East Anglia ONE North and East Anglia TWO Offshore Windfarms

Applicants' Comments on Suffolk Energy Action Solutions' Deadline 6 Submissions

Document Reference: ExA.AS-27.D8.V1

Date: 25th March 2021

| Important Hedgerows and Tree Preservation Order Plan Sheet Number: Sheet 2 of 12 | | | Rev | 5 | British National Grid OSGB36 |

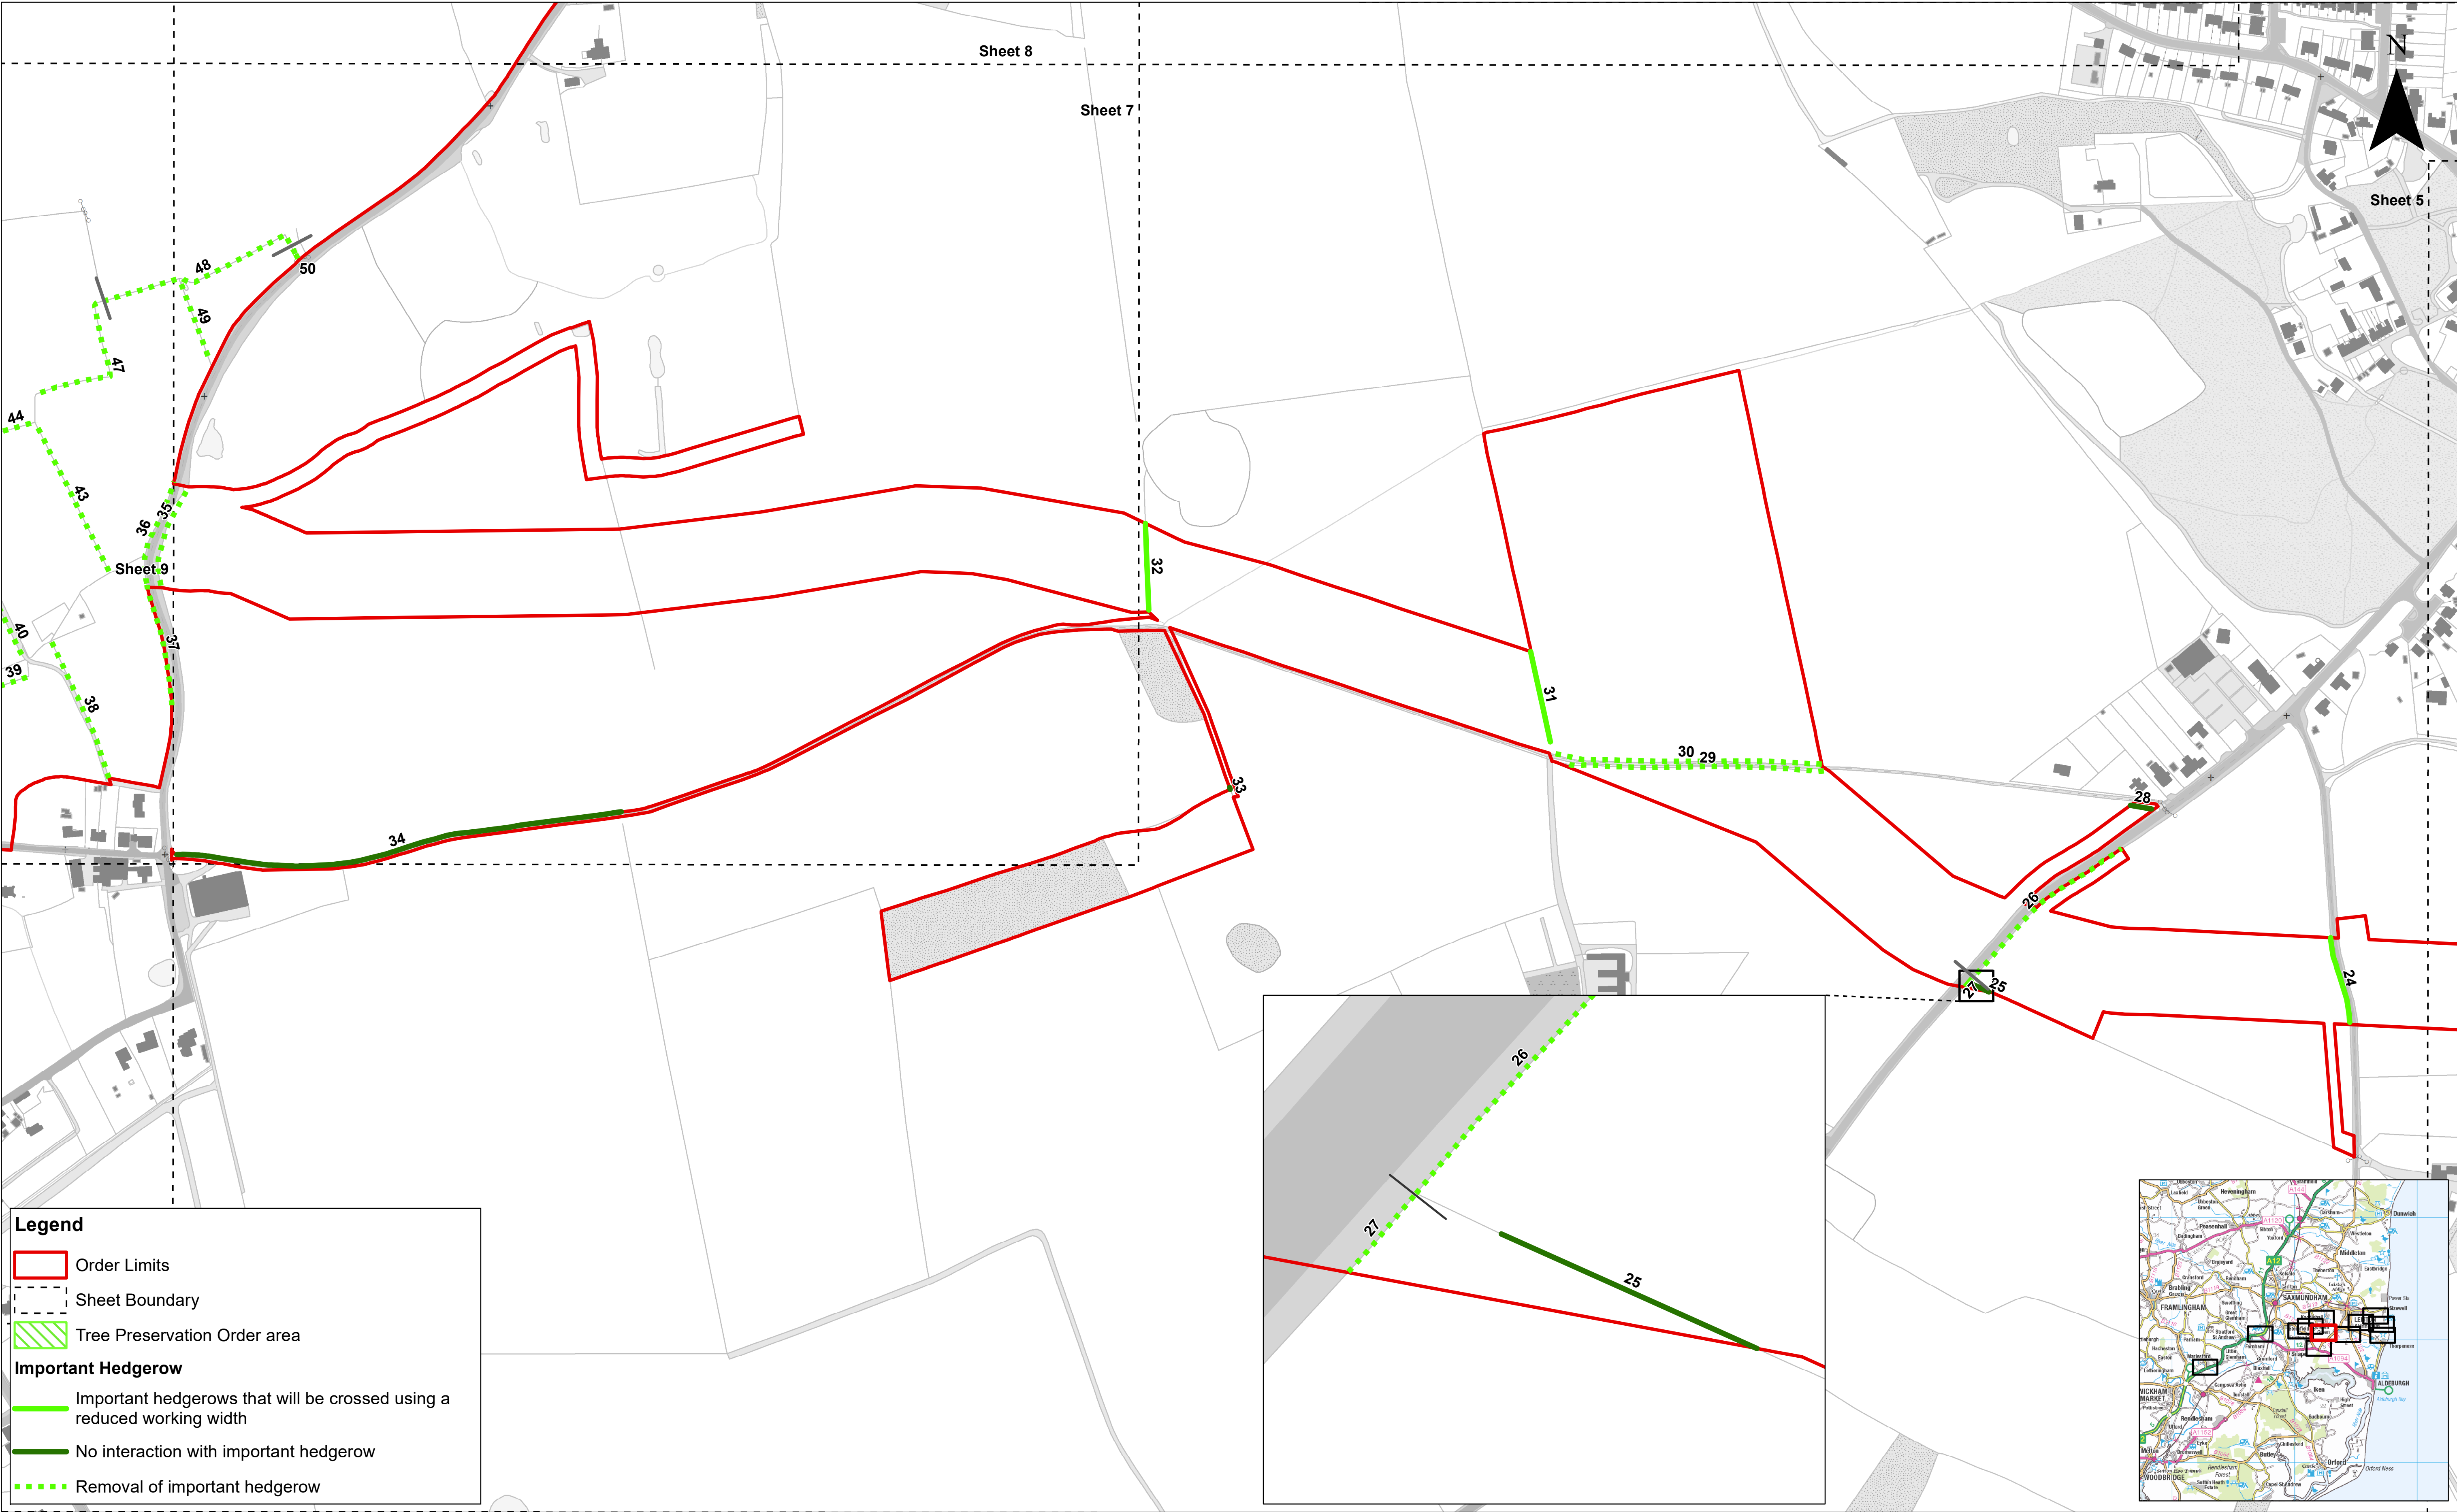
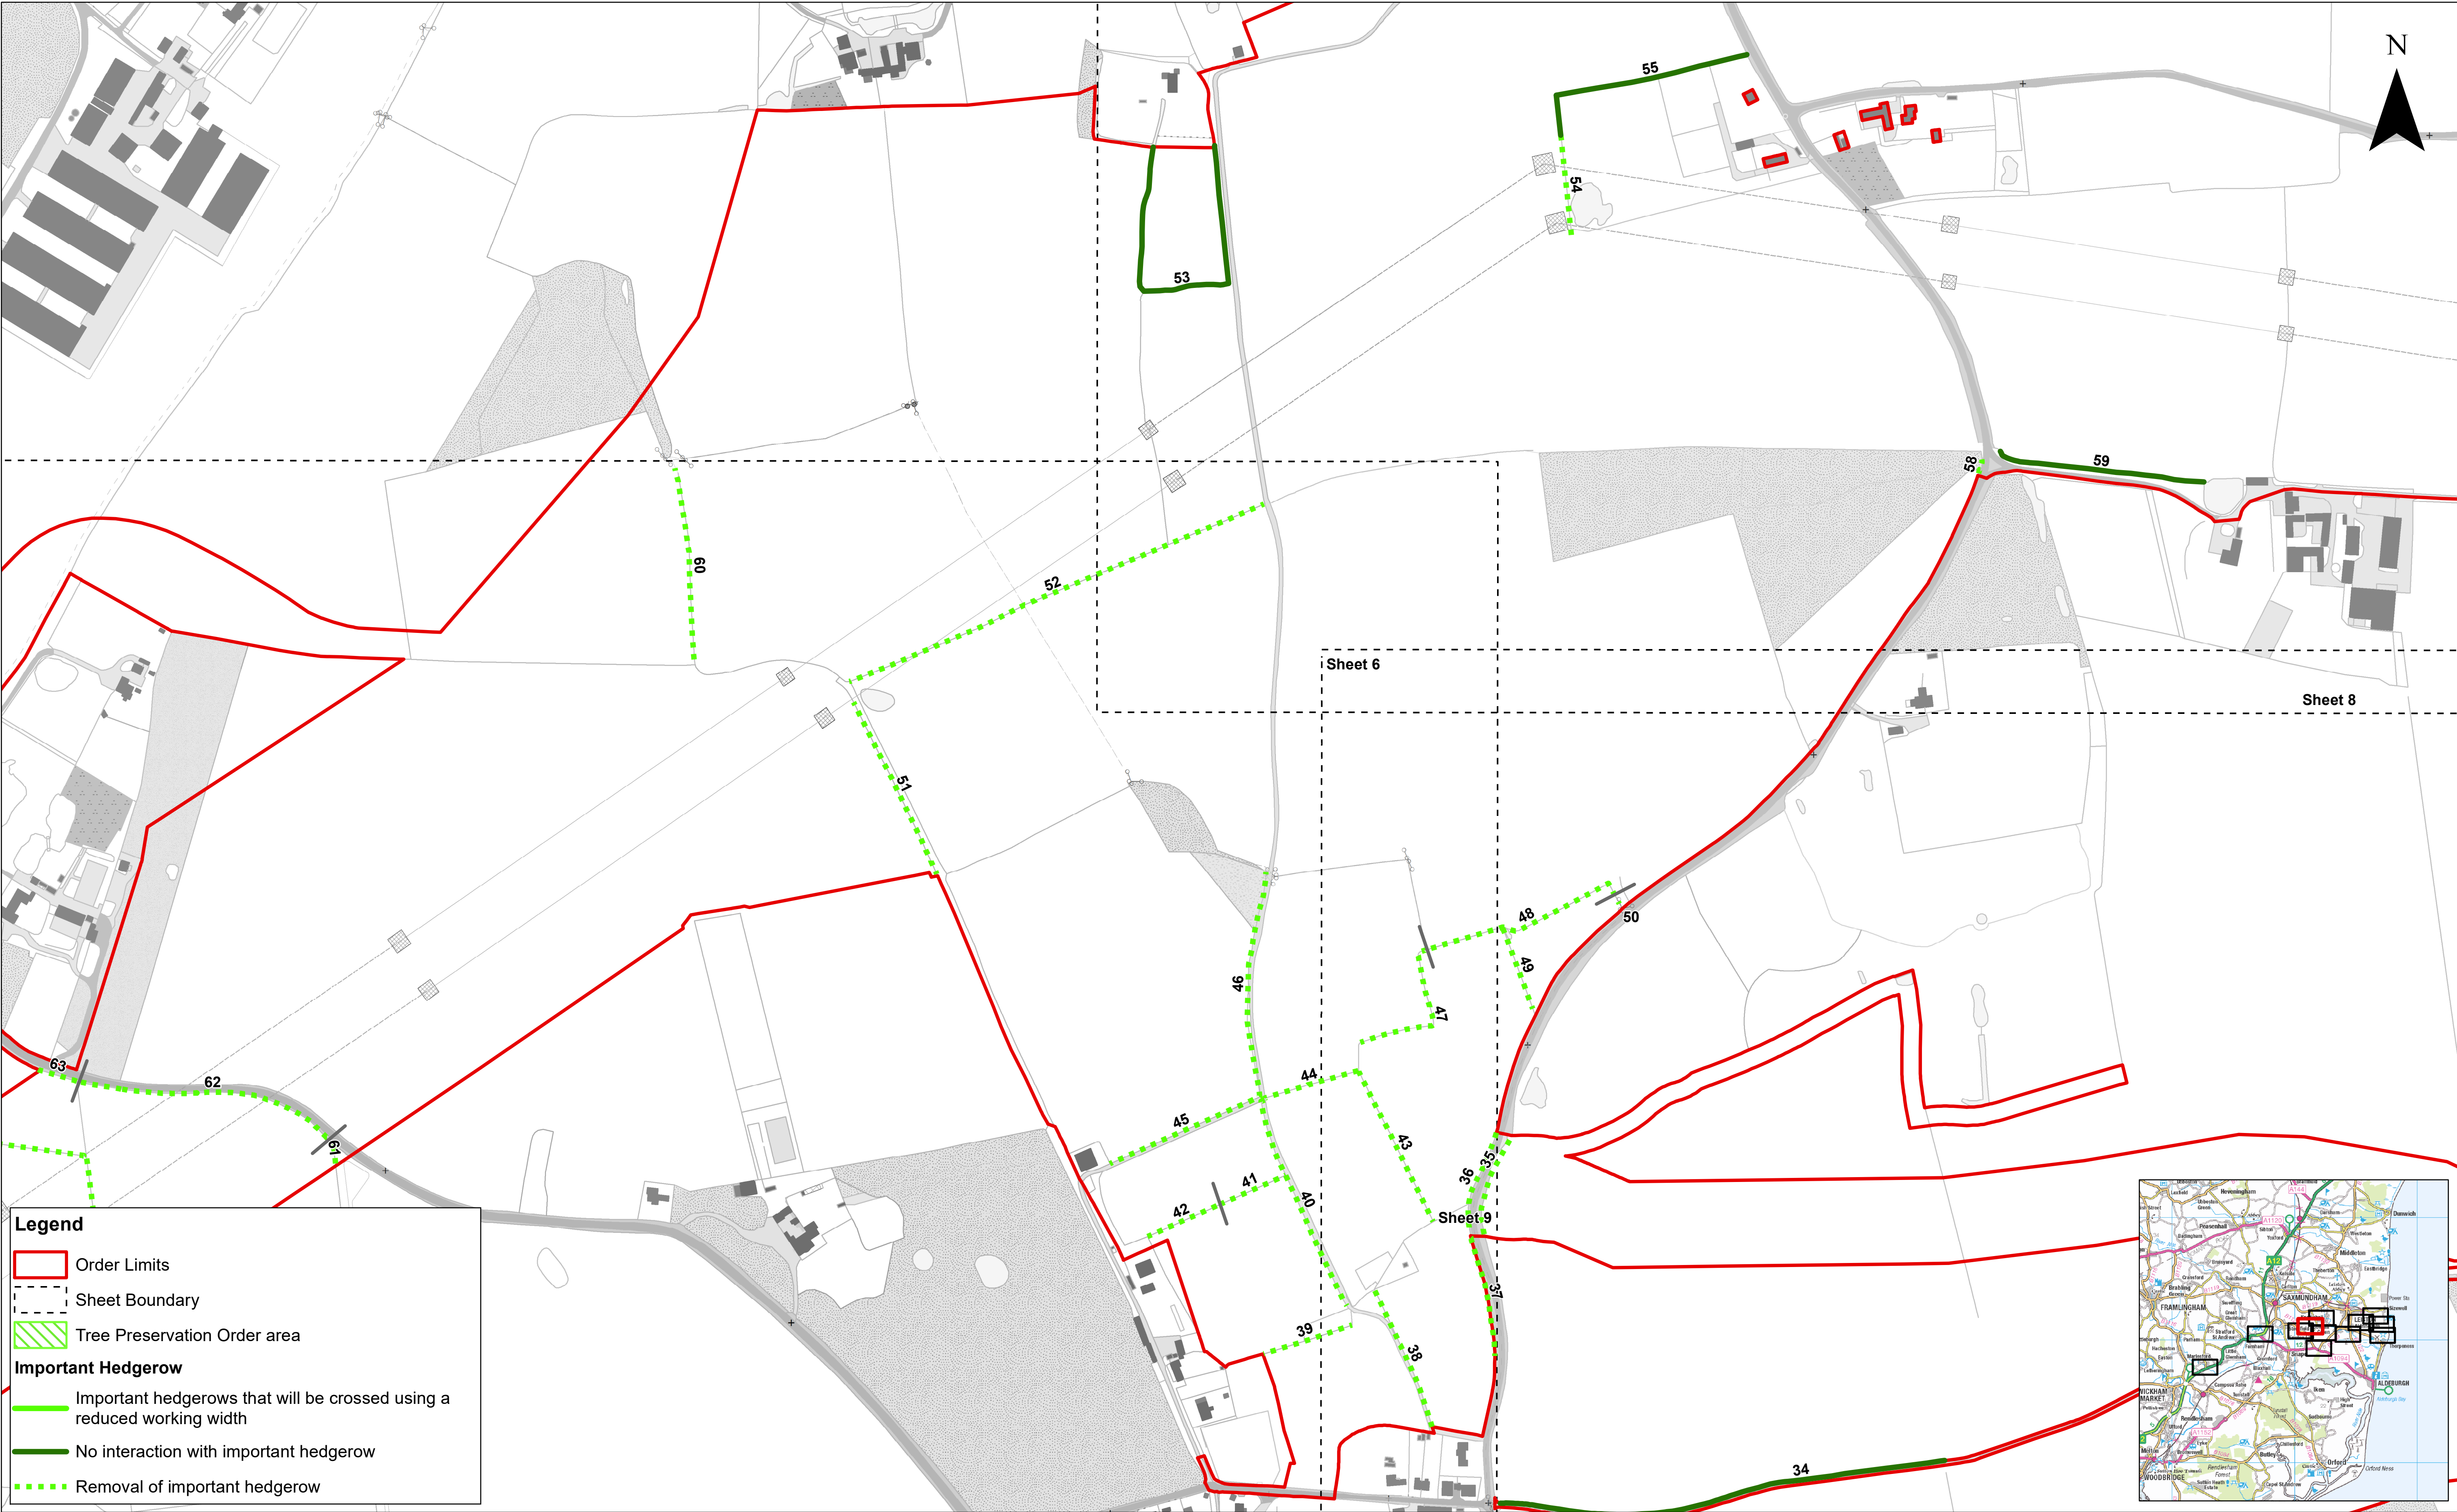
ID	SEAS' Comments	Applicants' Comments
45	6.10 Both hedges will have to be removed.	The Applicants note that the length of hedgerow associated with Fitches Lane required for removal in this area is important hedgerow marked 21 on sheet 5 of 12 of the Important Hedgerows and Tree Preservation Order Plan (REP3-010).
46	6.11 Fitches Lane and the paths through the wood are resources joining two villages, enabling children to walk to the Primary School, as well as offering places for children to play. Although there has been some development by the new owners in recent years (one owner's child has a bike track in an area of the wood), we still hear our migrant birds return each spring. The construction will remove this resource and the Lane.	Noted. The Applicants note that a temporary diversion of the public right of way (PRoW) E-260/007/0 (from the western end of Fitches Lane towards Coldfair Green) will be required during construction. This temporary diversion will be implemented in accordance with the final Public Rights of Way Strategy, which must accord with the Outline Public Rights of Way Strategy (REP3-024) and be approved by the relevant planning authority prior to undertaking works that would affect the PRoW, pursuant to Requirement 32 of the draft DCO (document reference 3.1). Pursuant to Article 11 of the draft DCO , temporary PRoW diversions must be provided to the standard defined in the Outline Public Rights of Way Strategy (REP3-024), to the satisfaction of the relevant highway authority, prior to the stopping up of the existing PRoW.
